Norwich to Tilbury

Document: 6.5.A1 Environmental Statement Appendix 5.1 - National
Grid's response to the EIA Scoping Opinion

Planning Inspectorate Reference: EN020027

- Legend**
- Scoping Report Corridor
 - Study Area (200m)
 - Cut line
 - Rivers
 - Deciduous woodland
 - No main habitat but additional habitats present
 - Traditional orchard
 - Ancient & Semi-Natural Woodland
 - Ancient Replanted Woodland

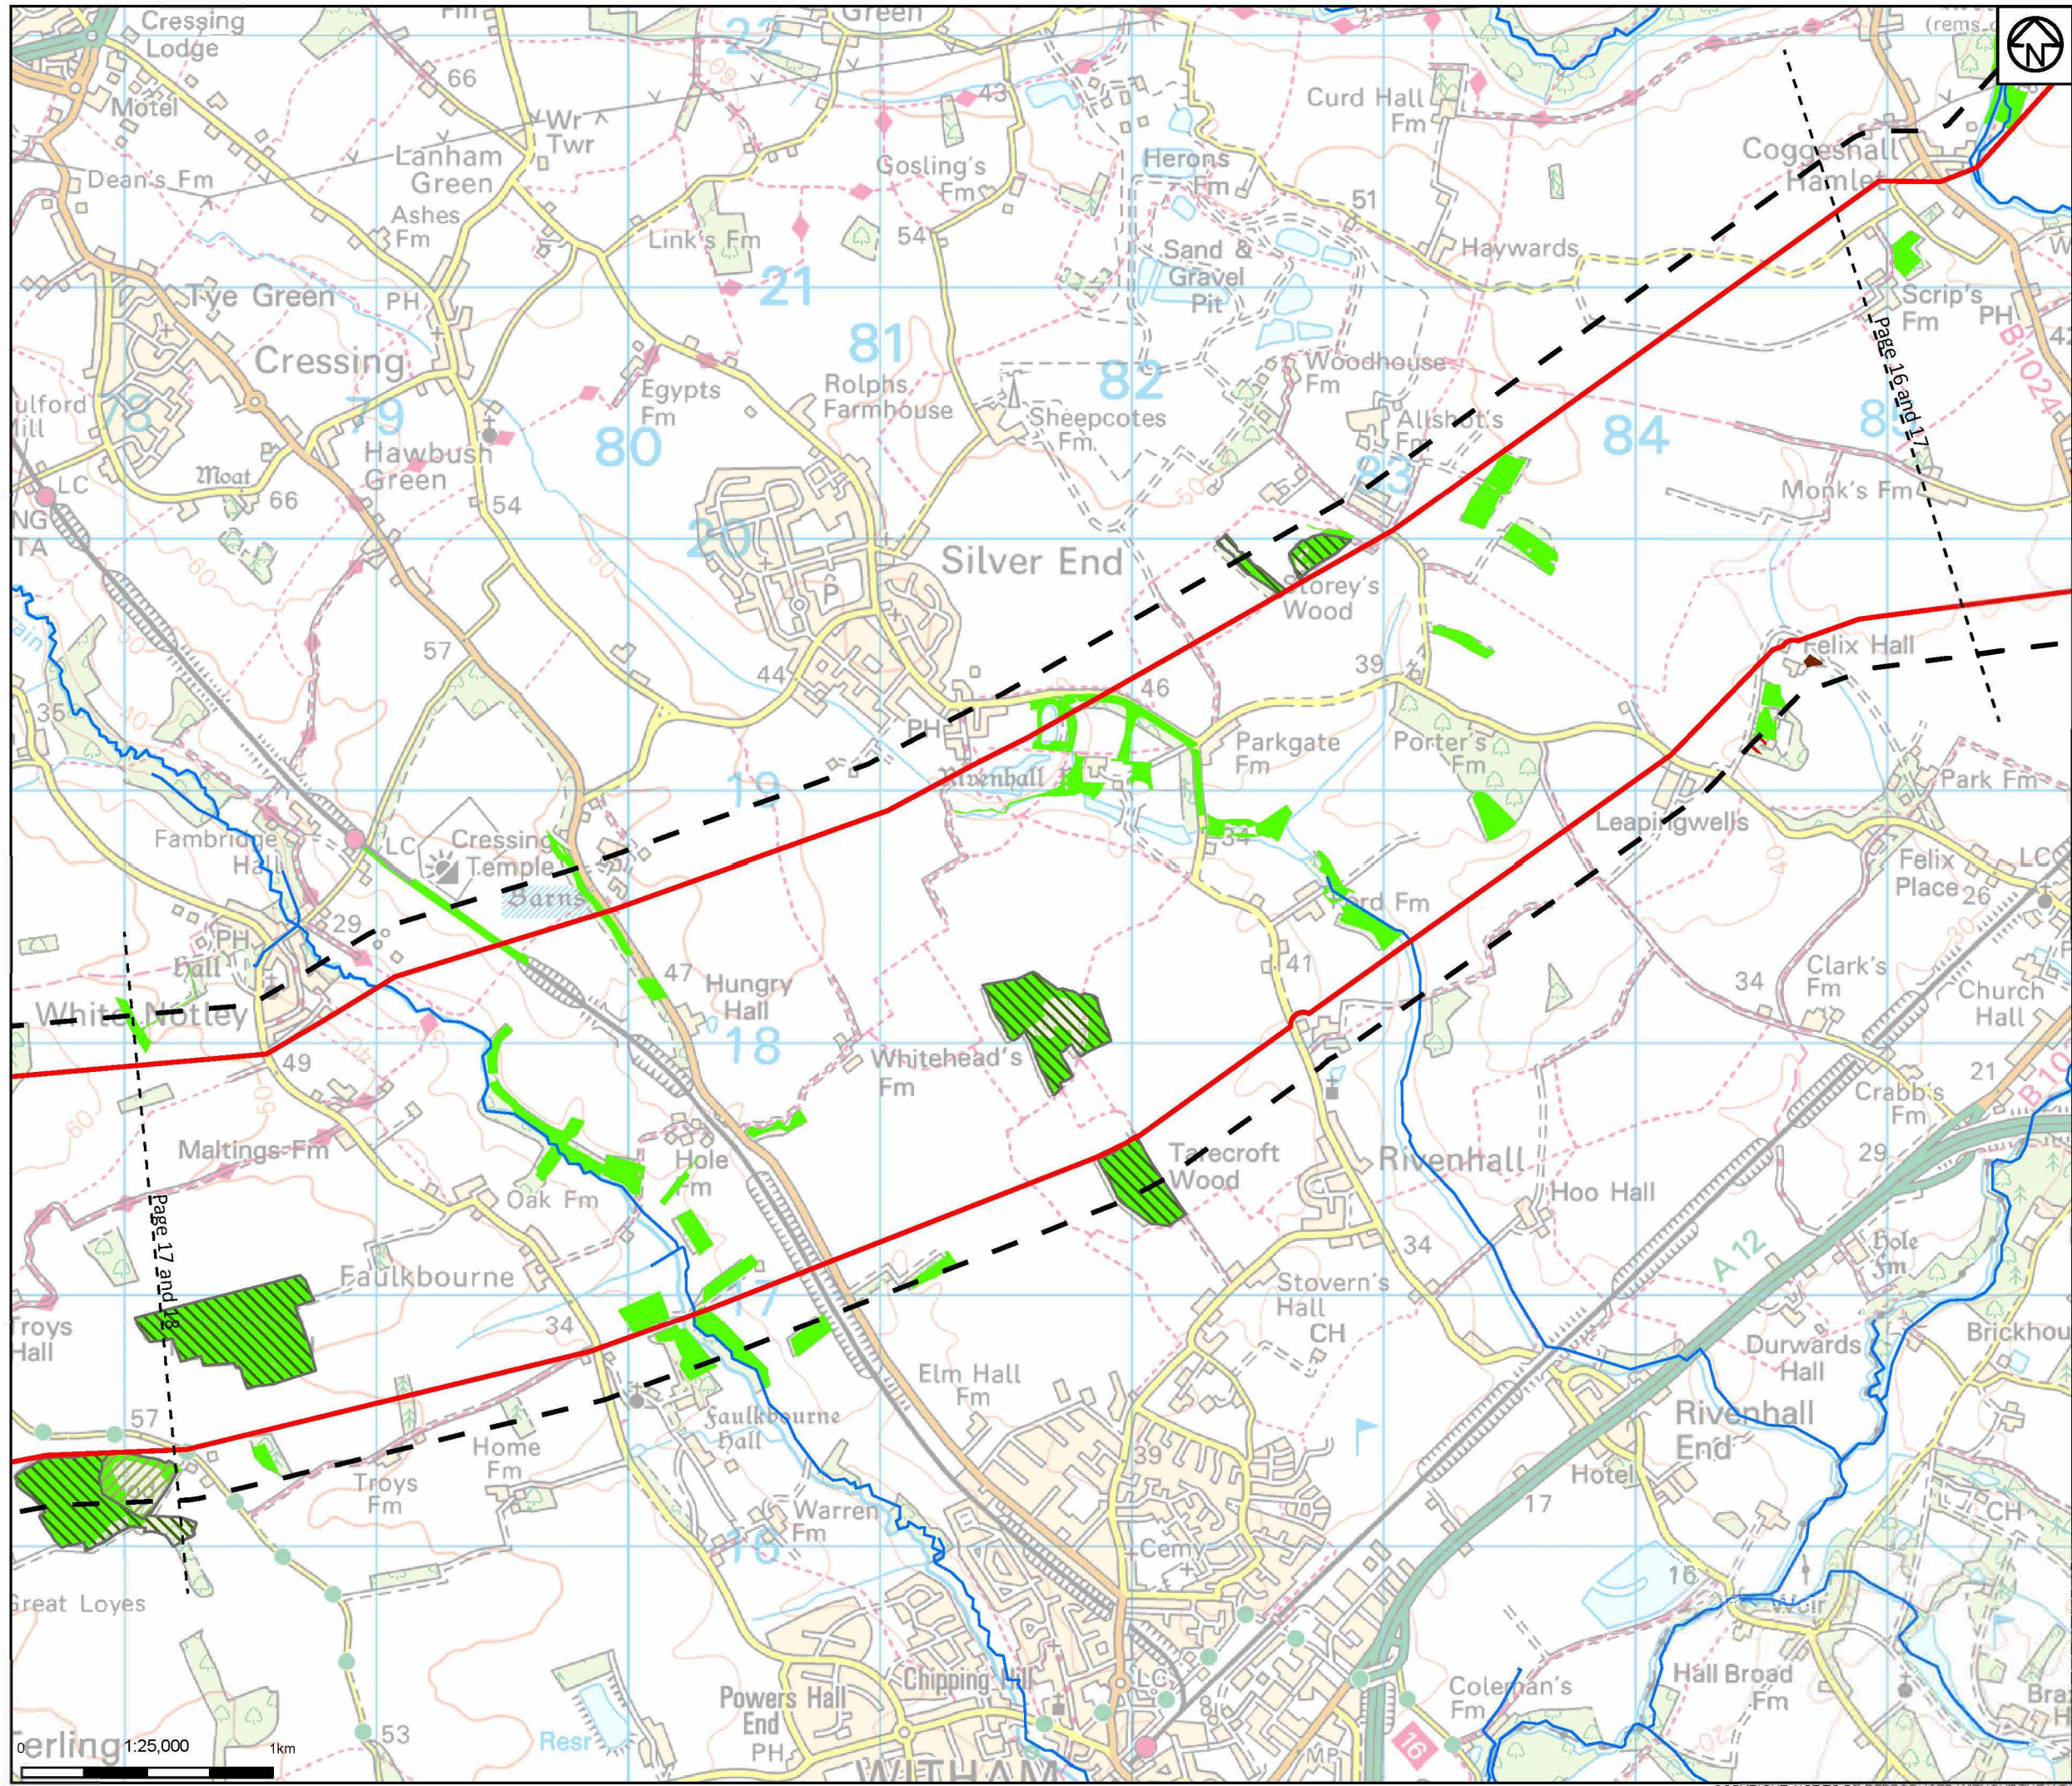
| Reference from the EIA Scoping Opinion | Aspect | Planning Inspectorate's Comment in the EIA Scoping Opinion | Project Response |
|--|--|---|--|
| Figure 8.3 | Legend | <i>The Legend to Figure 8.3 includes 'No main habitat but additional habitats present'. The ES should explain what is meant by this statement.</i> | <i>'No main habitat but additional habitats present'</i> is a specific category within the Natural England spatial dataset, that describes the geographic extent and location of Natural Environment and Rural Communities Act (2006) Section 41 habitats of principal importance. Habitat survey results are presented within Appendix 8.1: Habitat Report (document reference 6.8.A1). |
